From: Jean Fraser
To: Greer, Tom
CC: DiPierro, Philip; Federle, Tom; Lloyd, David; Mohr, Stephen; Newell,...
Date: 4/16/2014 4:39 PM
Subject: Re: FW: 13143 - 118 Congress Street, For Final Approval

Thank you for these which I understand have been revised to address the conditions of Planning Board approval.

SUBDIVISION RECORDING PLAT
C1.0

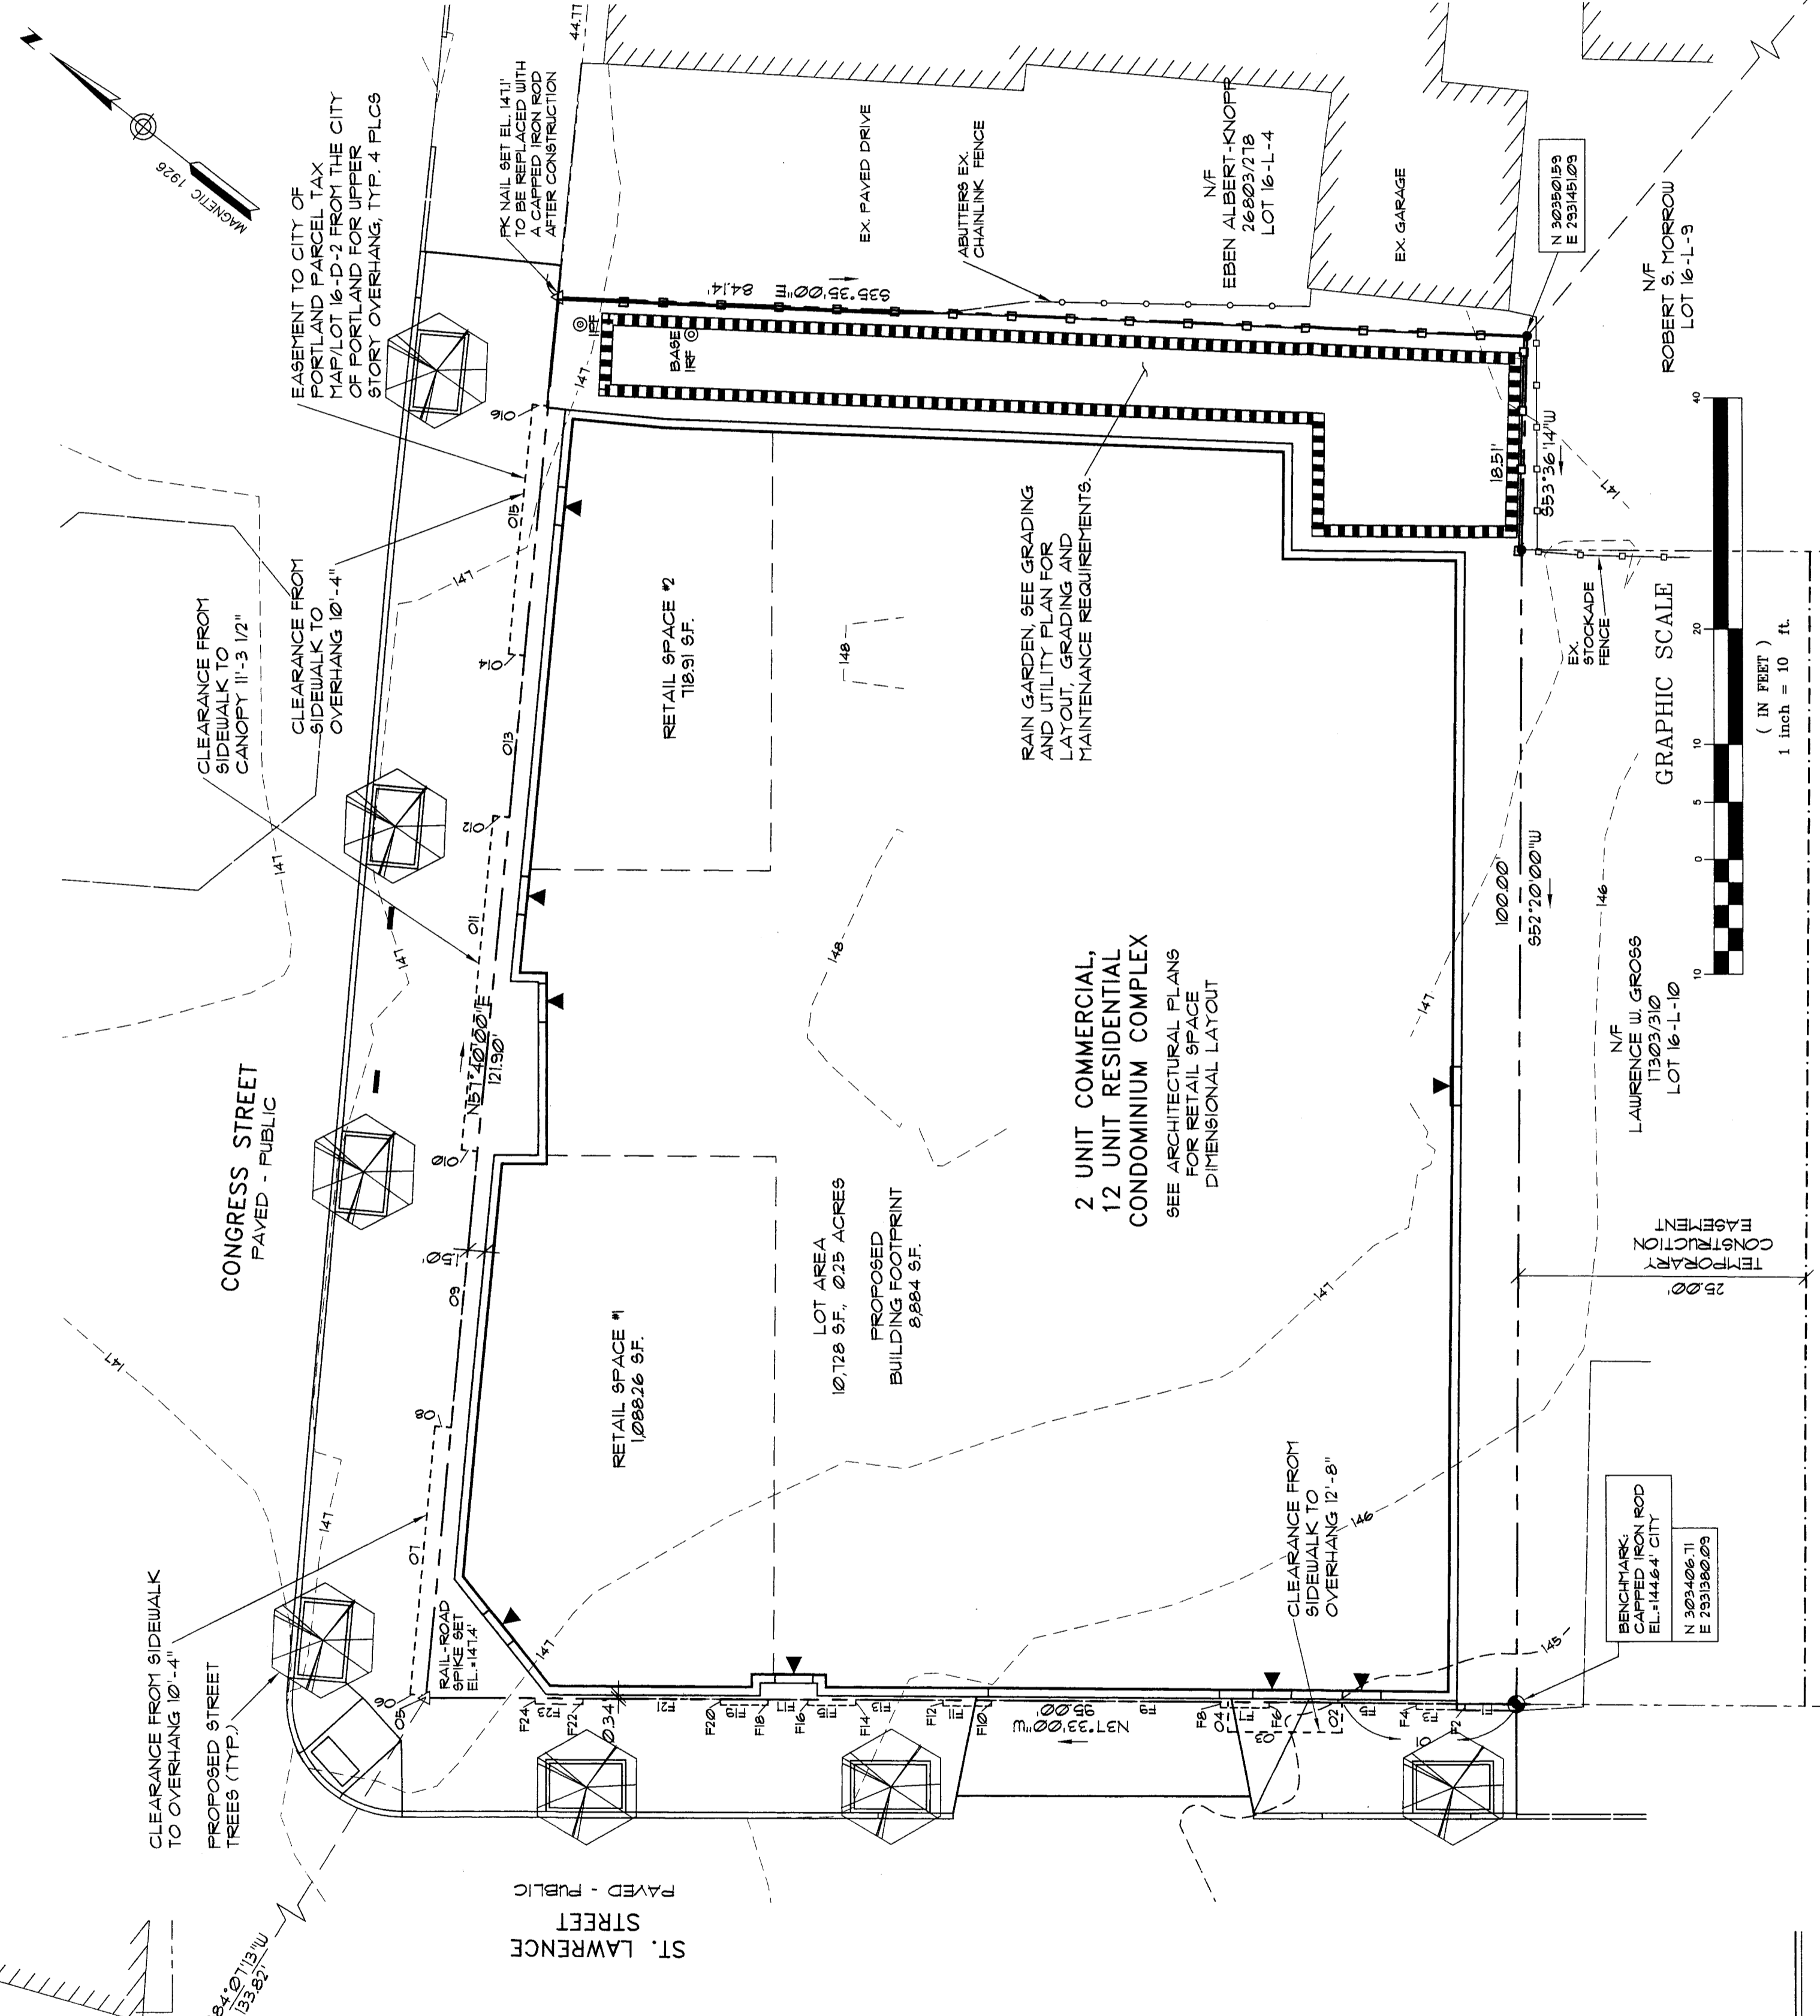
The Subdivision Plat needs revisions as advised to you in e-mails dated 4.8.2014 and 4.9.2014 and reiterated 4.15.2014;

LANDSCAPE PLAN
SCALE: 1" = 8'-0"

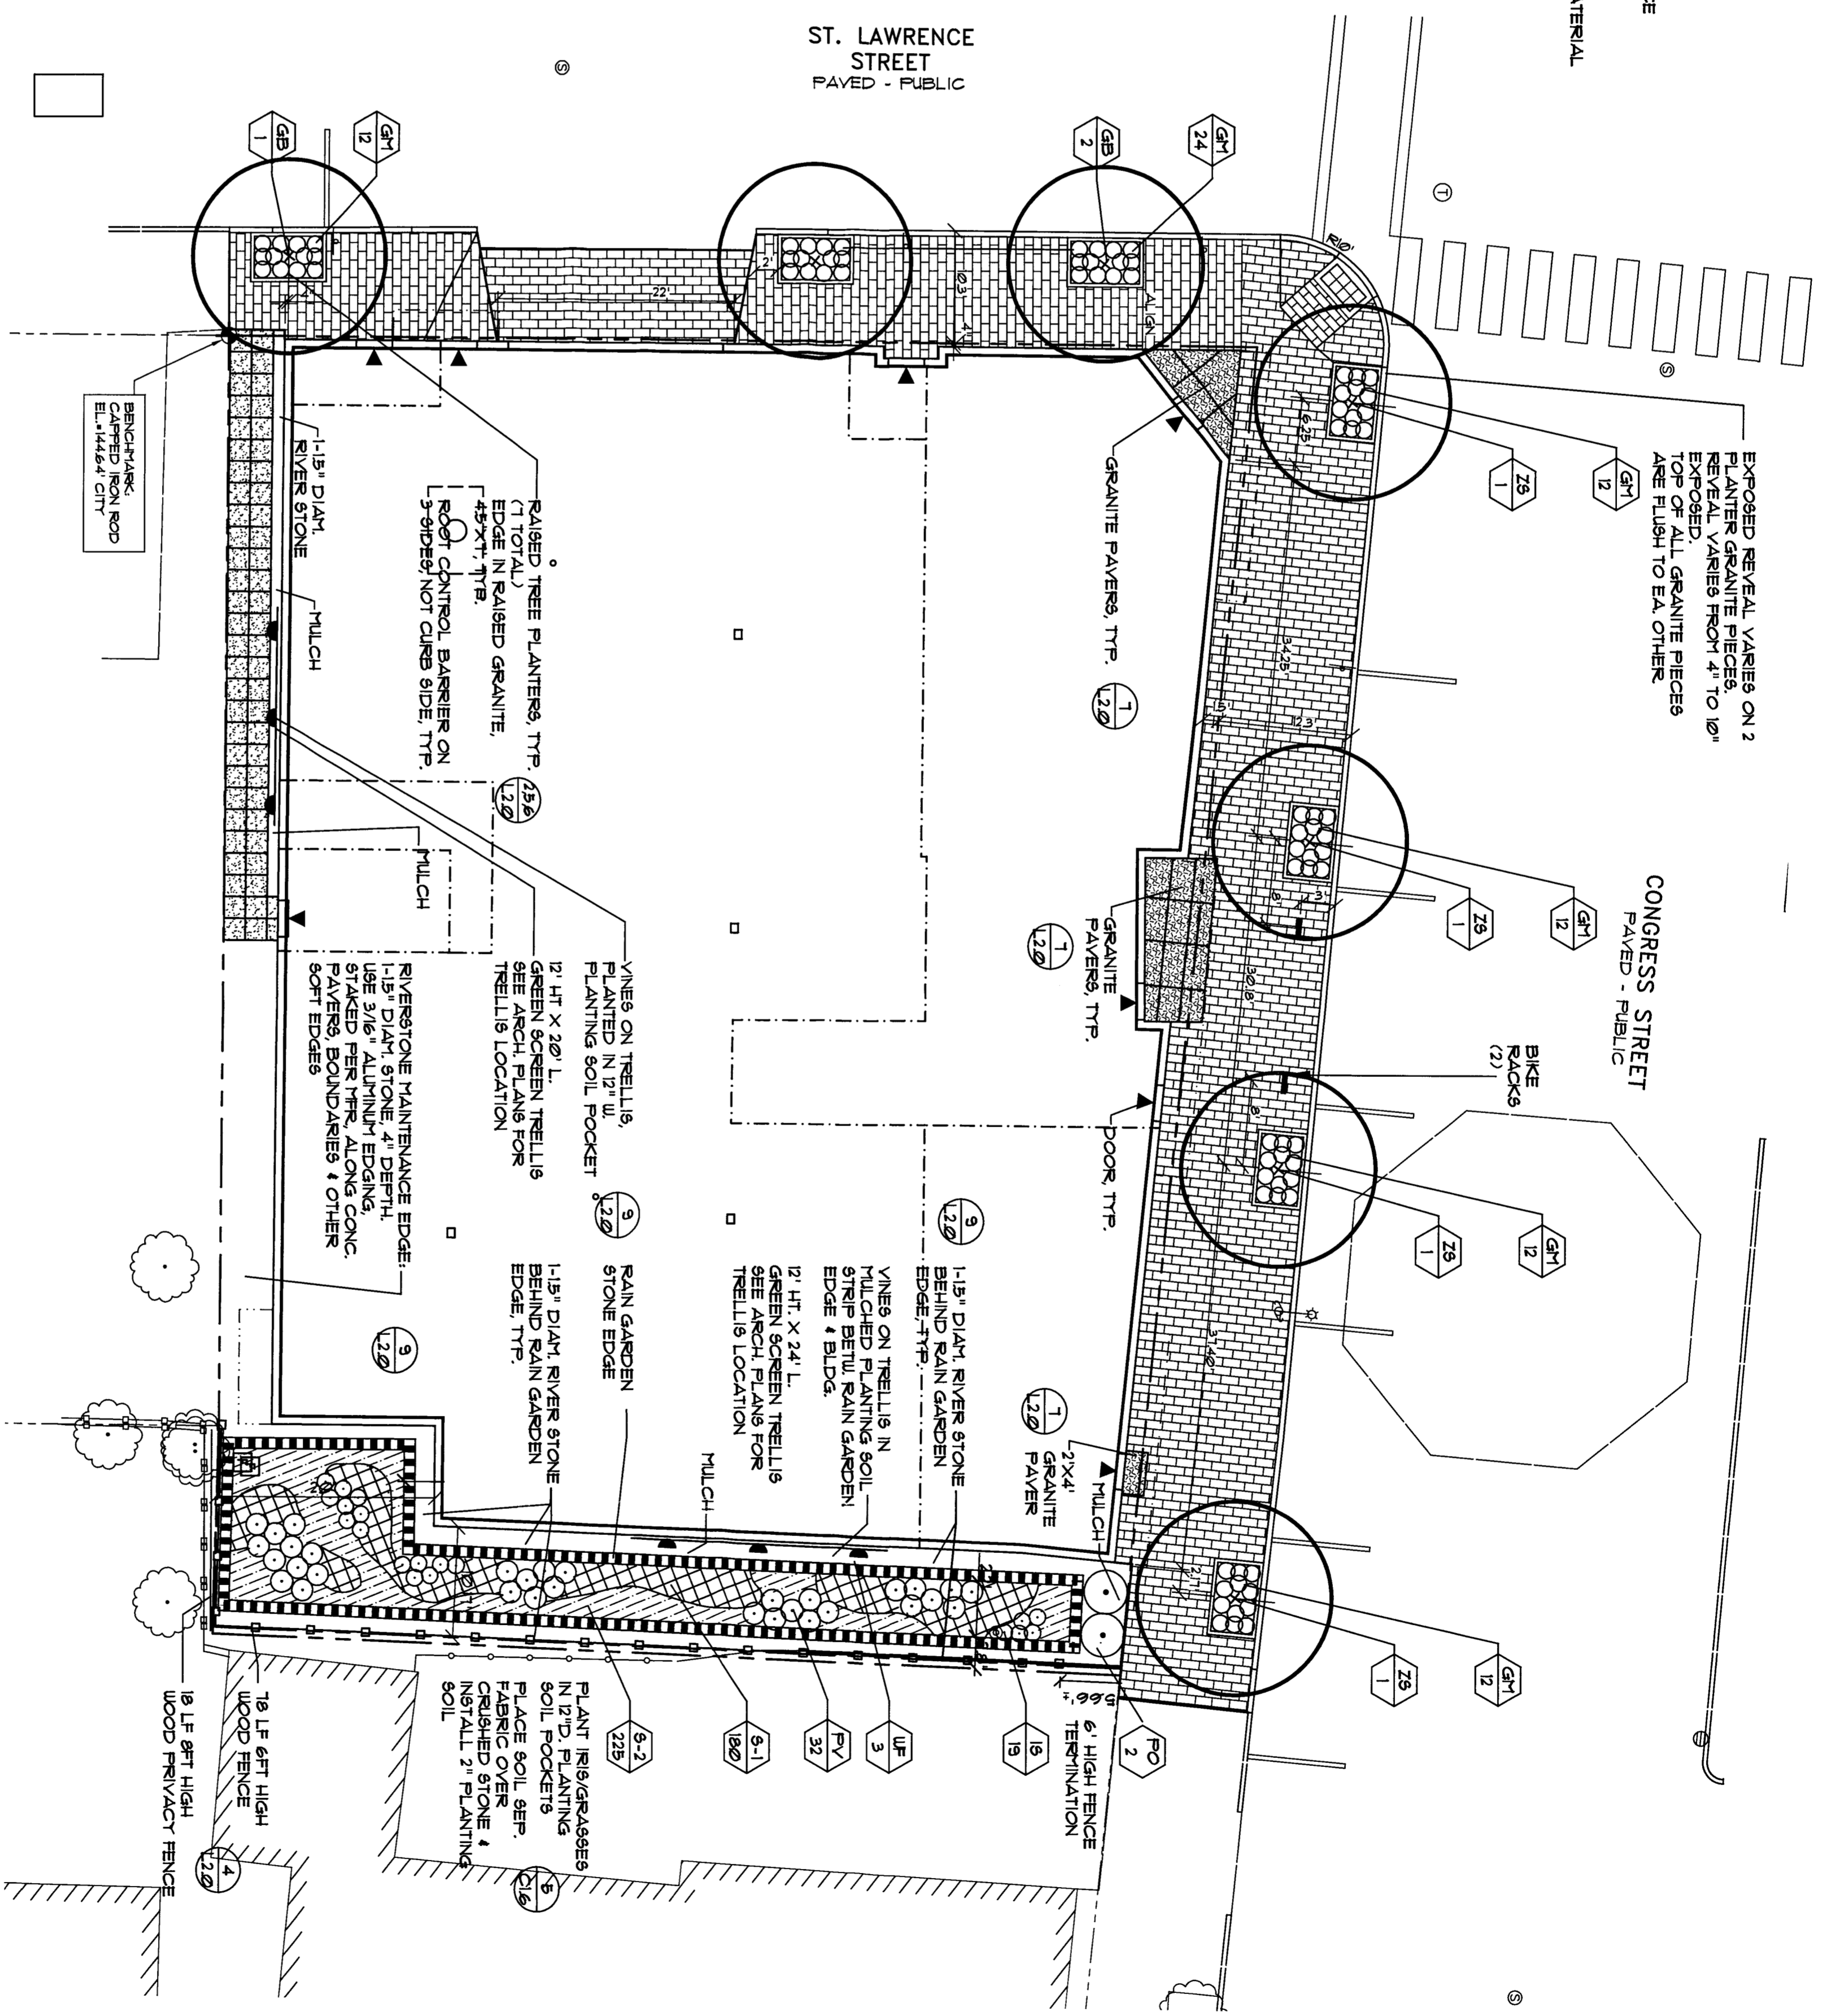
The location of street trees and associated wells/surrounds is not yet approved as we await the information requested in condition v and detailed in my e-mail of 4.9.2014 {all of the plans should be consistent in respect of the street trees}

1 CITY OF PORTLAND BRICK SIDEWALK/CURB DETAIL
L2.0 NOT TO SCALE

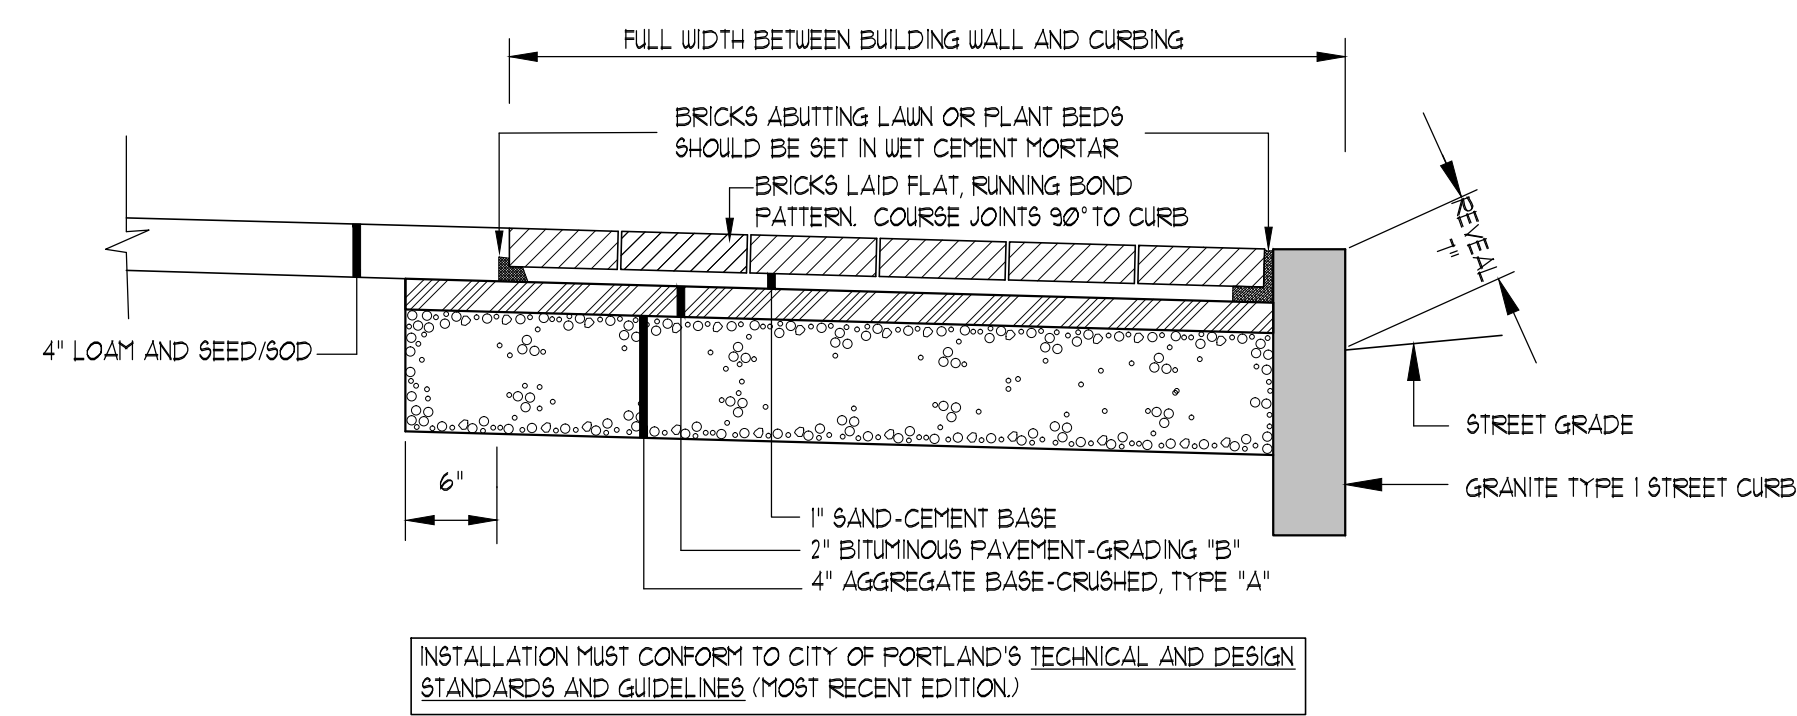
Please add the brick sidewalk detail;
